Subject: DC/22/01865 - FUL Glebe House, The Street, Stowlangtoft

David Pizzey FArborA
Arboricultural Officer

TITLE: ACCESS LAYOUT PLAN

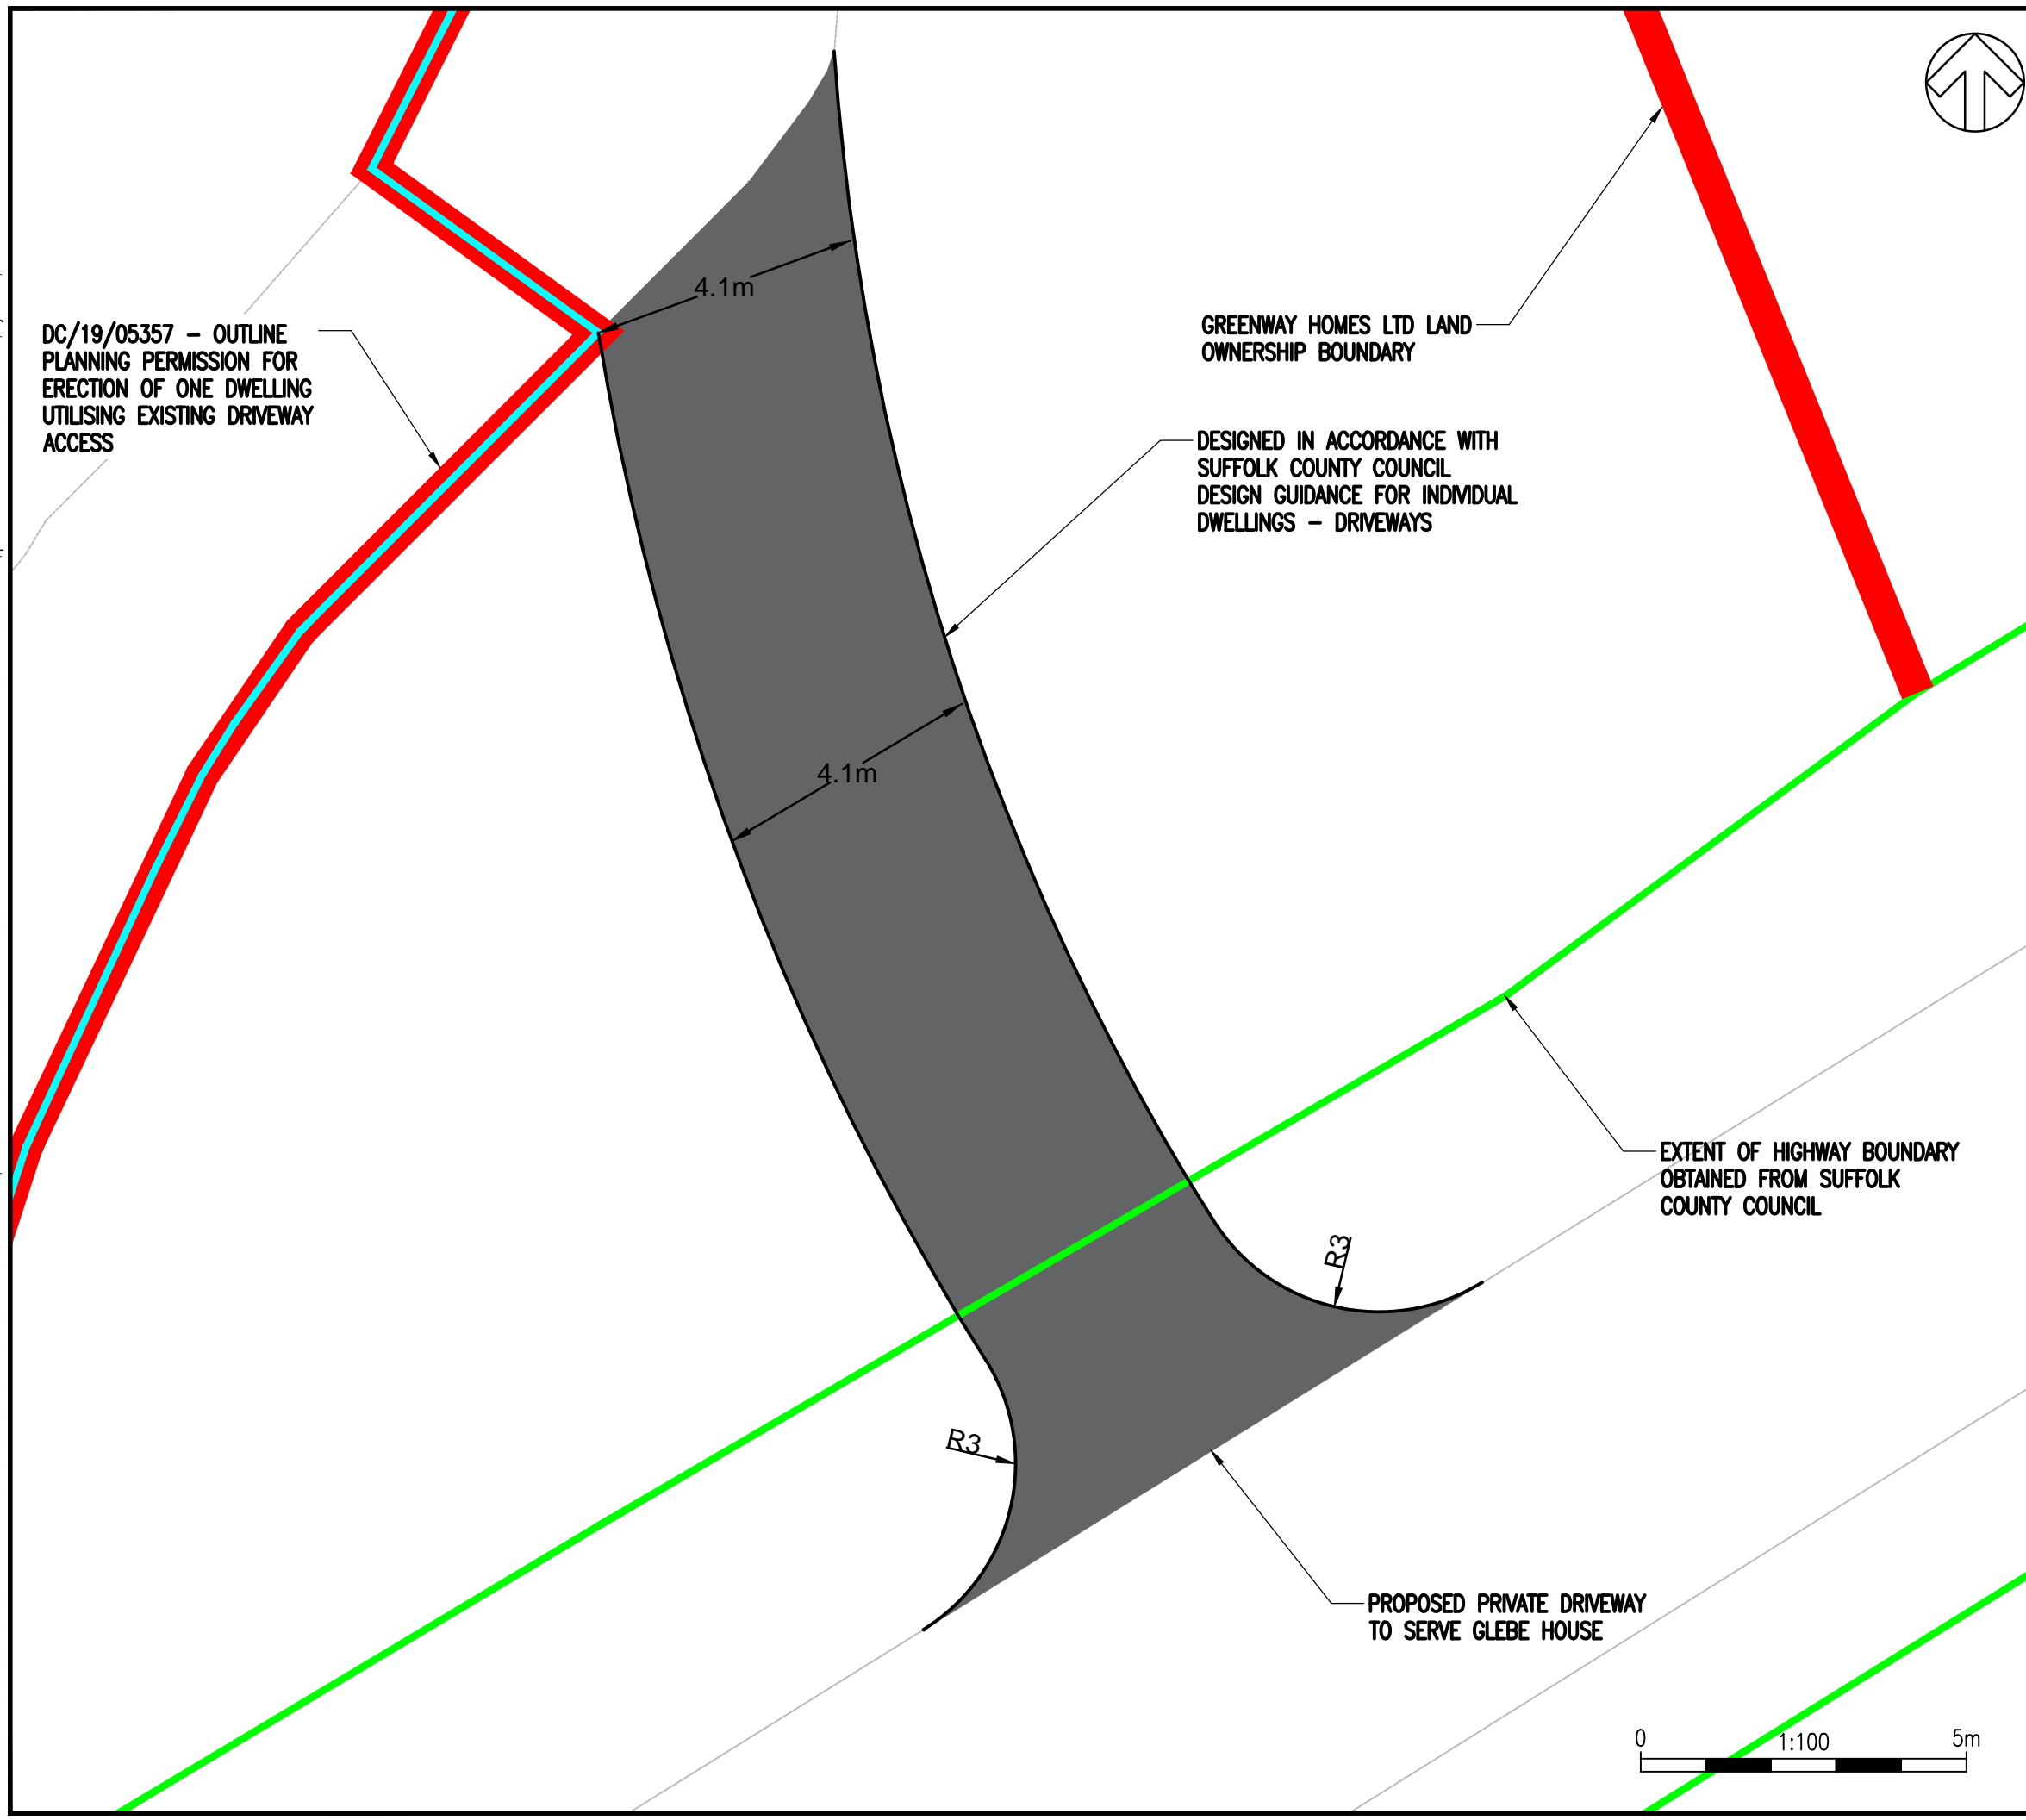
This proposed new vehicular access goes directly through an area of TPO trees and therefore we will require an arboricultural report in order to assess the impact and viability of this application.
